### Section 75W Amendment to MP10\_0016 - Scottish Hospital Paddington

This letter constitutes a request to amend the Project Approval for MP10\_0016 (Scottish Hospital Paddington) issued in May 2012 under the former Part 3A of the Environmental Planning (EP&A) Act 1979, and is prepared on behalf of Brookfield Multiplex Constructions Pty Ltd. The application is made in respect to land at 2 Cooper Street Paddington, legally described as Lot 2 DP 607572.

Modification is sought to the approval in respect to eight (8) elements. Each is addressed separately below. Supporting documentation in respect to each of the modifications is provided with this application and is listed against each item for ease of reference.

Attachment E: Site Establishment - Stage 1 (PM-P-2002, Rev 4) with T5 removed

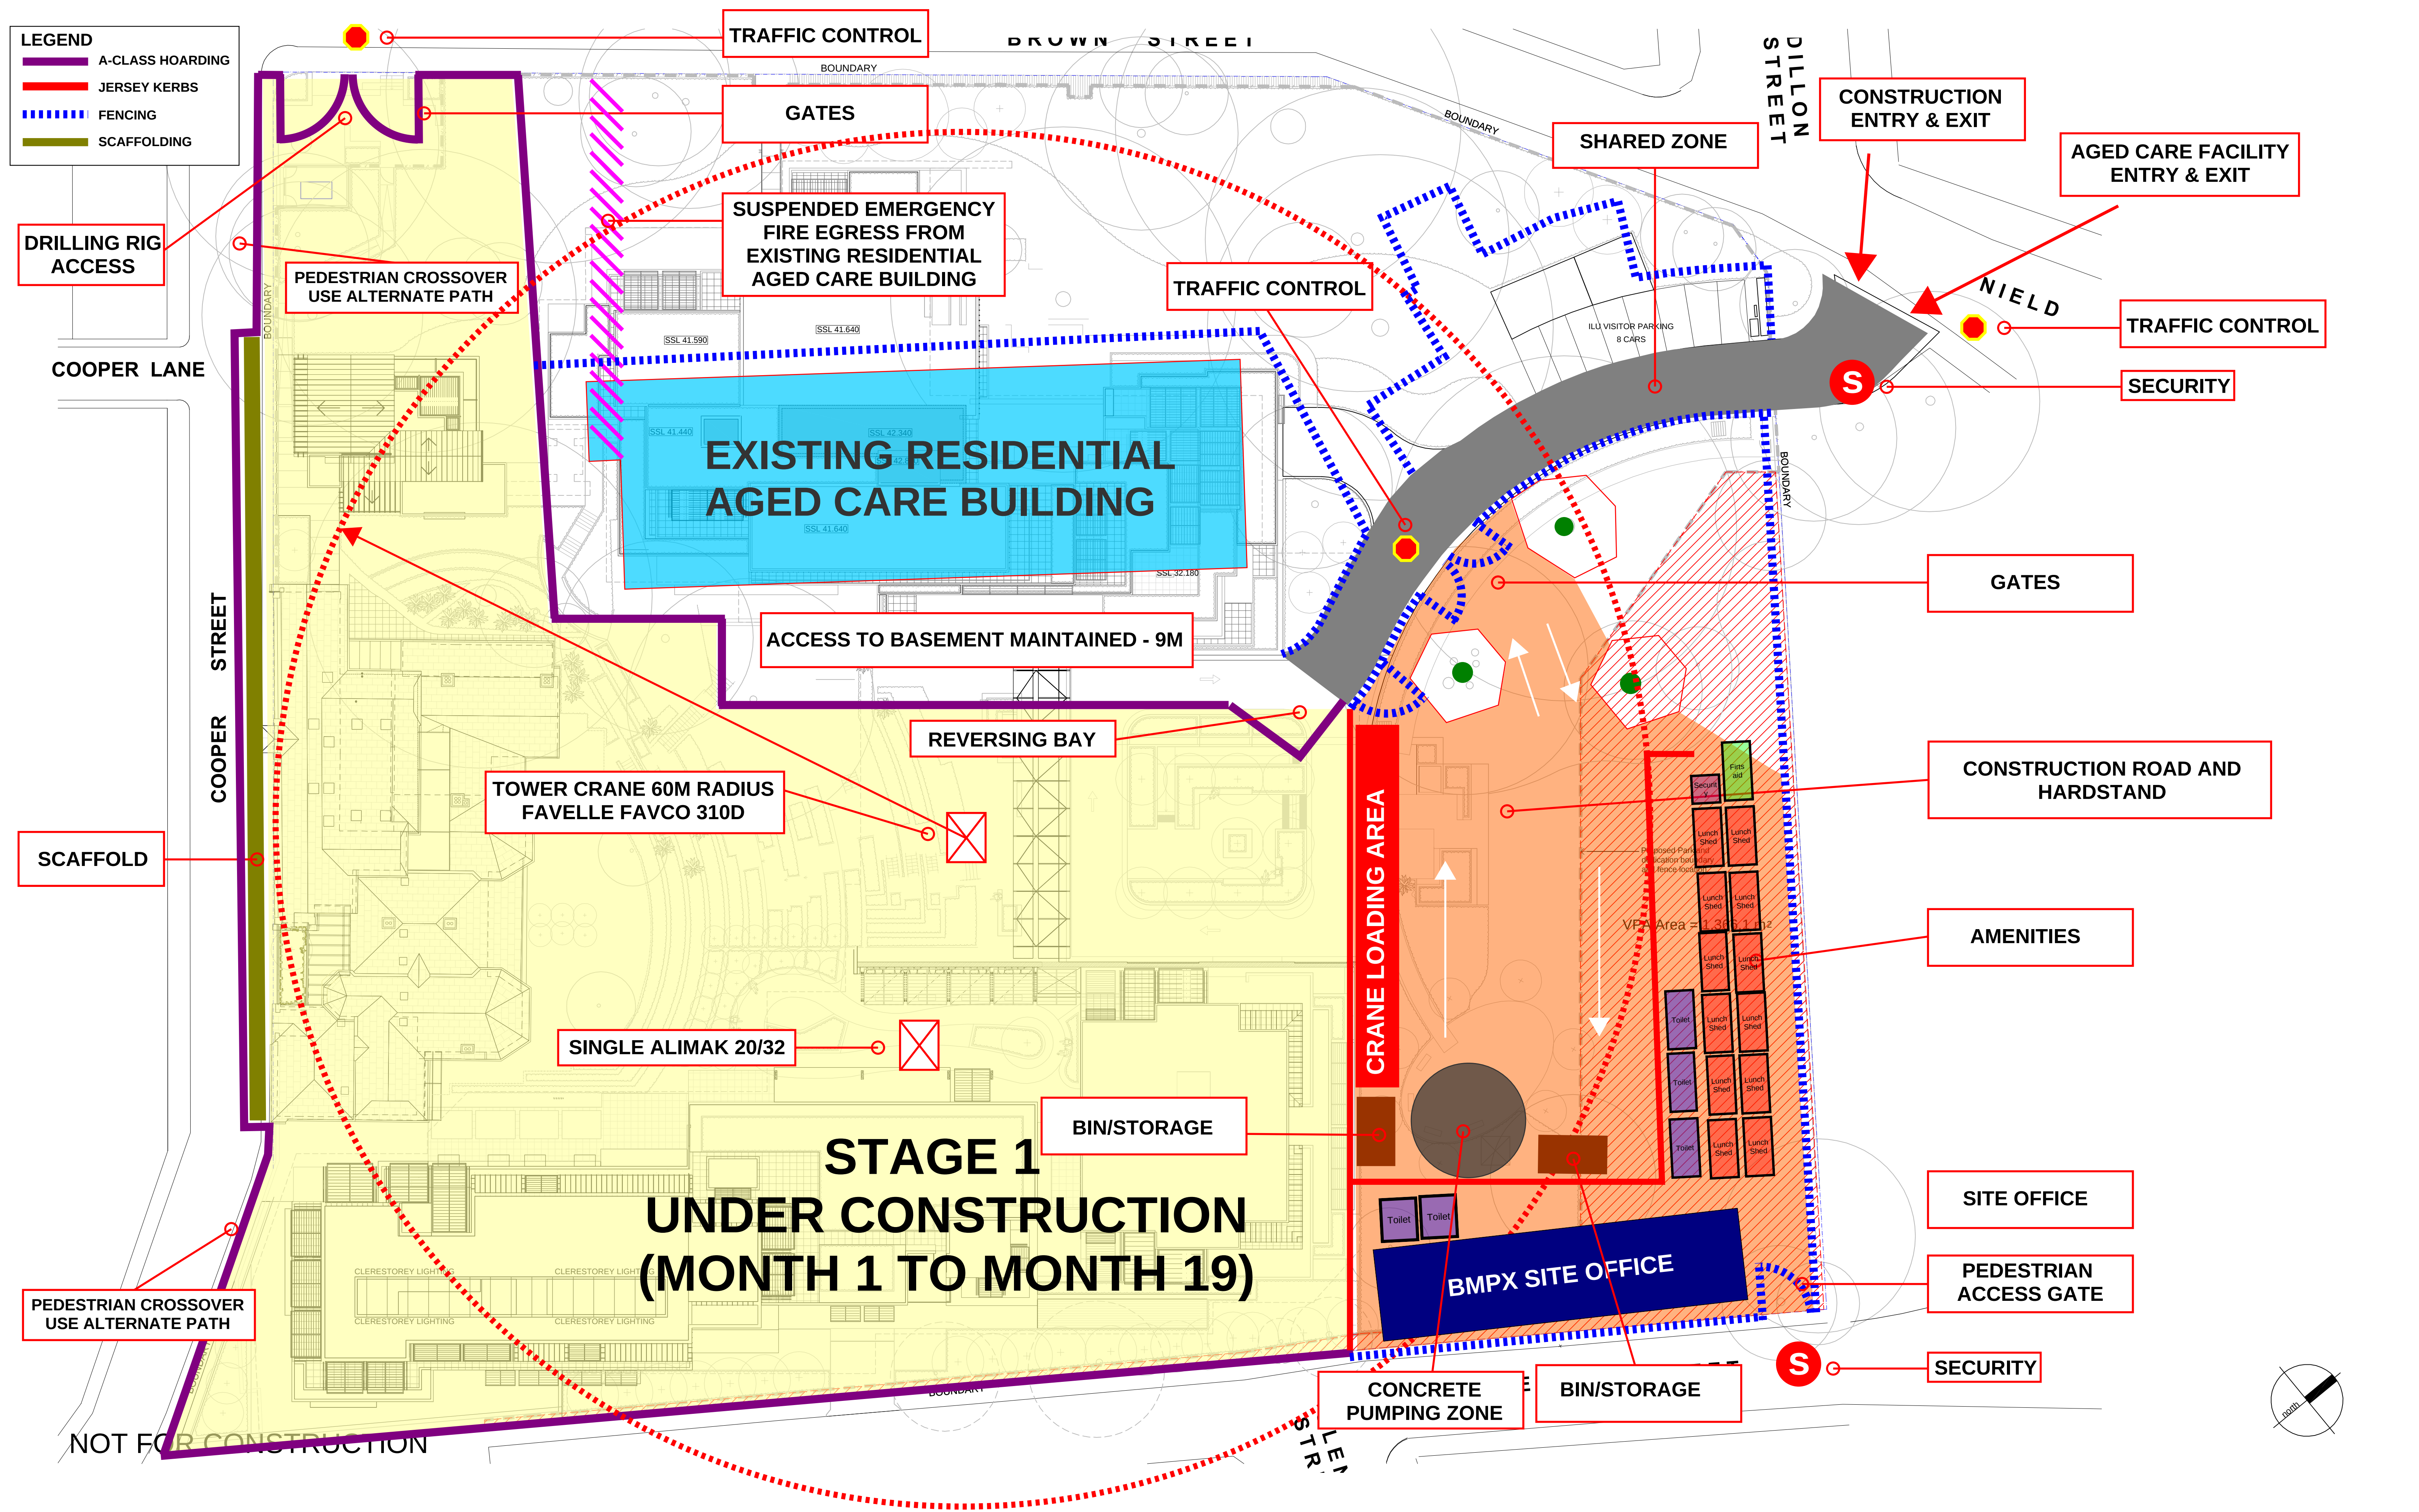
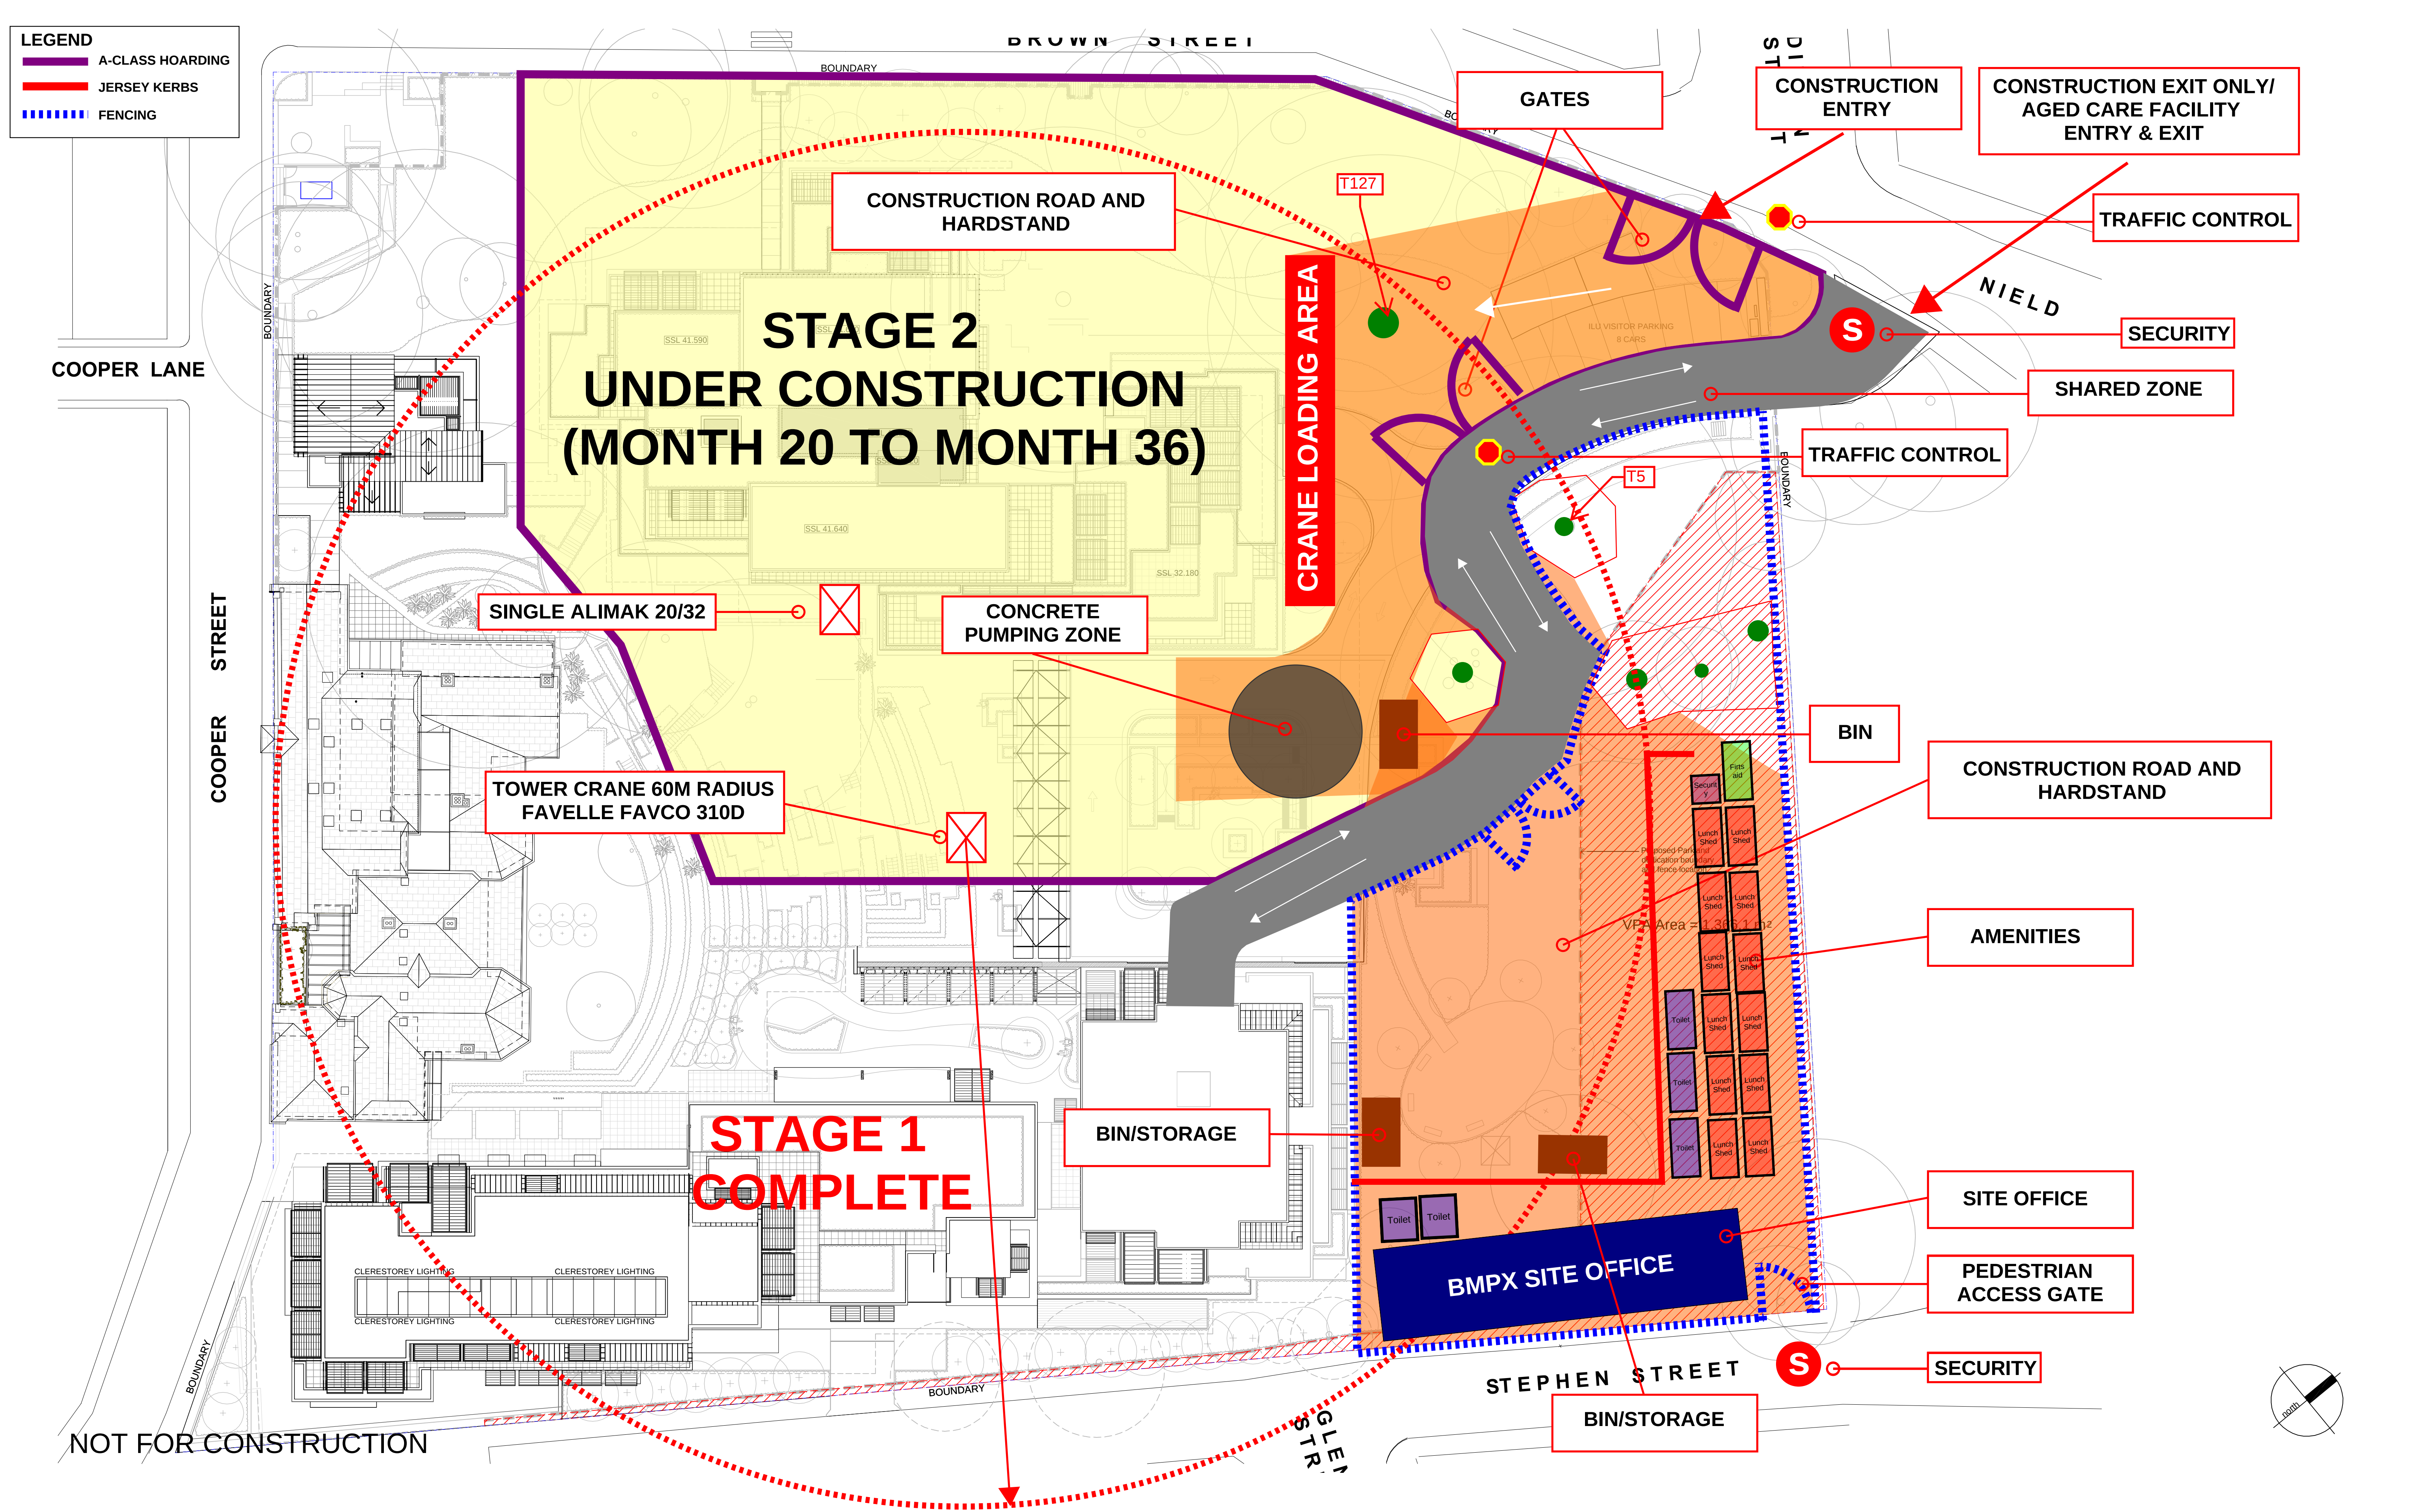
Since approval, the layout of the construction vehicle access roadway for the Stage 2 construction works has been refined. In order to protect heritage listed Tree 6, the construction driveway is required to be located from the south to the north of that tree, in the location of Tree 5 therefore requiring its removal.

- It will provide better Stage 1 hardstand layout benefiting Heritage Listed Tree 6. Trucks and vehicles will not need to exit the gate south of Tree 6 indicated on PM-P-2002-Rev 3. This temporary driveway south of Tree 6 has not yet been constructed.
